Our Ref: BR/276/20/DOC

Approval of details reserved by condition imposed under ref BR/32/16/PL relating to Condition No 3 - new boundary treatments, 6 - pedestrian visibility spays and 7 - covered & secure cycle parking.

3 Glencathara Road Bognor Regis PO21 2SF

Arun District Council have decided to **APPROVE details reserved by this condition**

PROJECT NUMBER	3 GLE-18	DRAWING NO	A101 REVC
DATE	5th January 2021		
DRAWN BY	June Grinstead		
CHECKED BY		SCALE	1:100 / A3

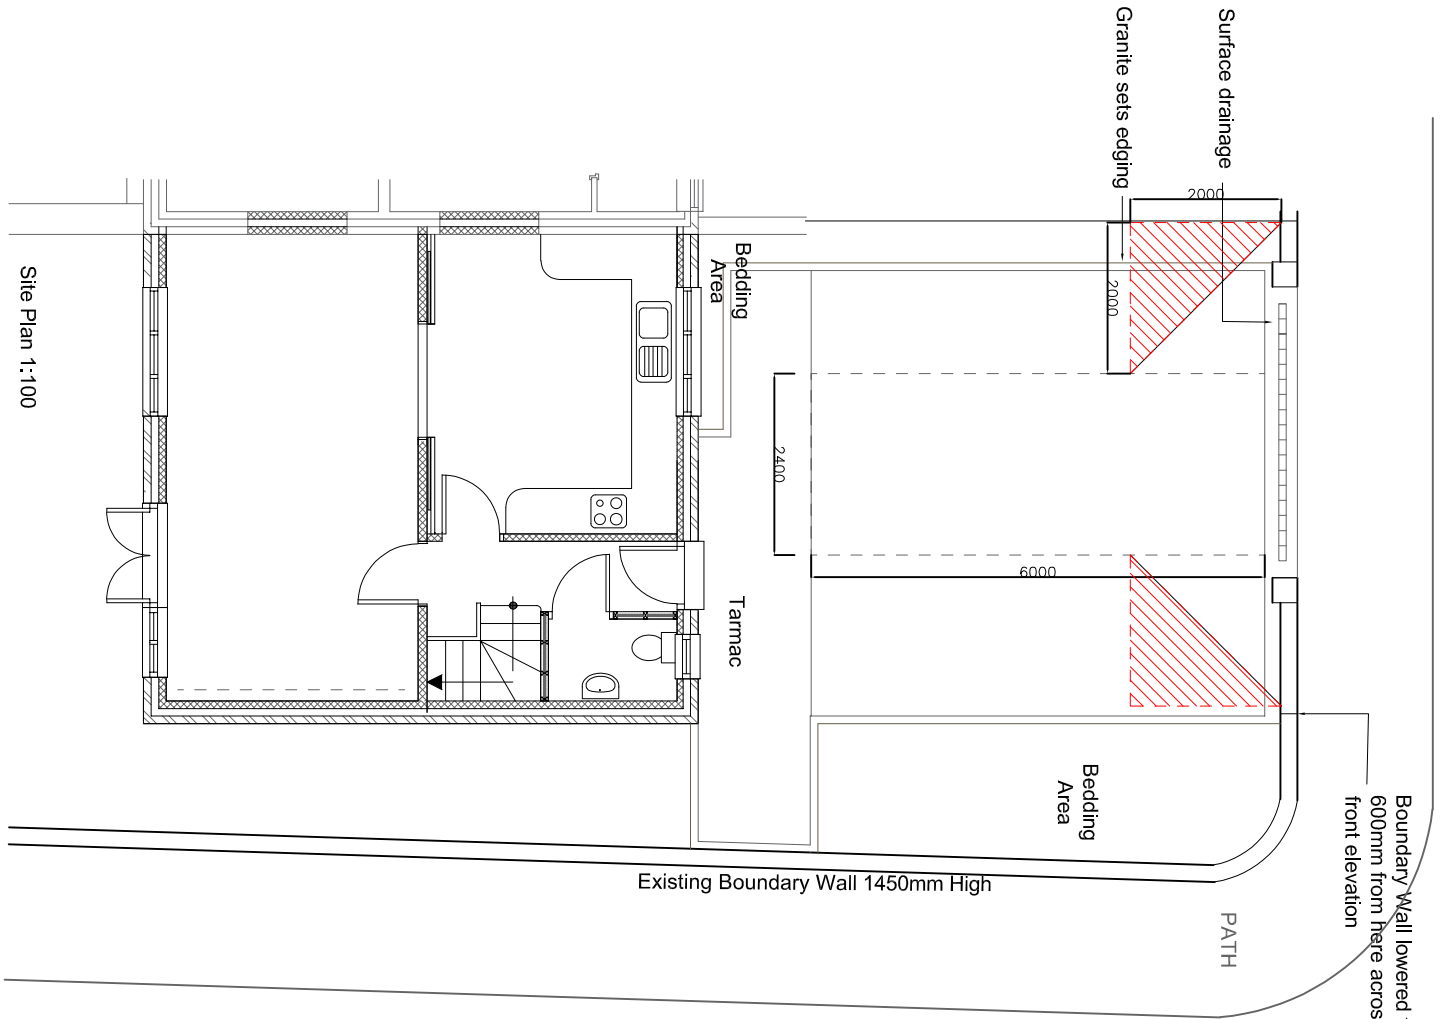
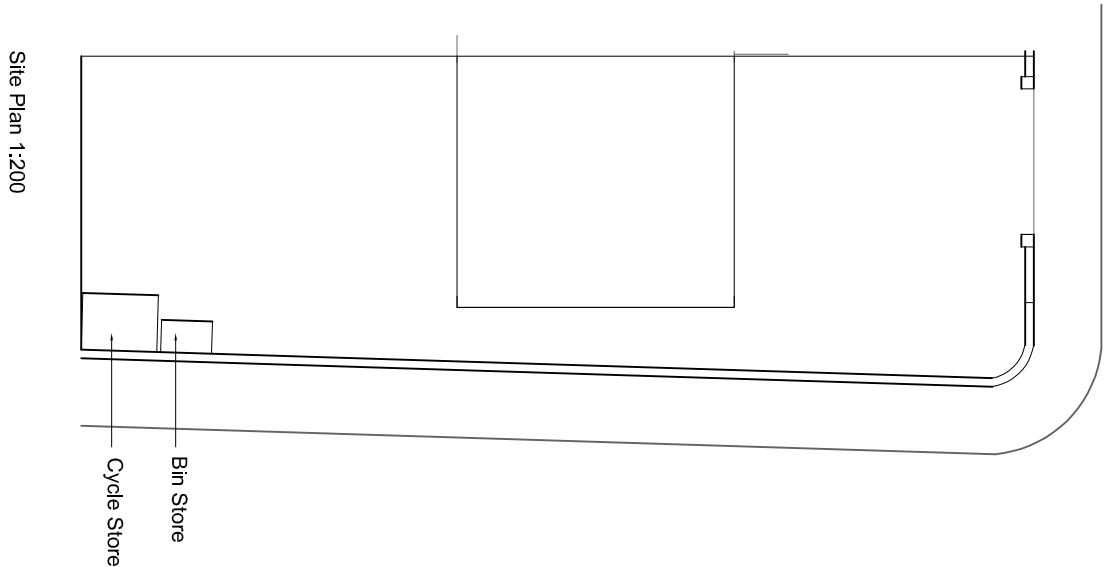
The submitted site plan 1:100, Dwg No A101 Rev C in respect of boundary treatment indicates provision of 1.45m high existing boundary wall to the east and 0.6m boundary wall to the front (north) with gateless entrance as shown on Appendix B (site photos).

The submitted site plan 1:200 and a drawings of timber clad bin storage, Dwg No A101 rev C indicates provision for the storage of 2no waste bins, one will be for general waste and the second will be for recycling in the position indicated on site plan 1:200.

The condition is therefore fully discharged on the understanding that the boundary treatment as shown on submitted drawings and provided photographs and a provision of waste bins will be permanently retained (as approved) in a condition that is fit for purpose.
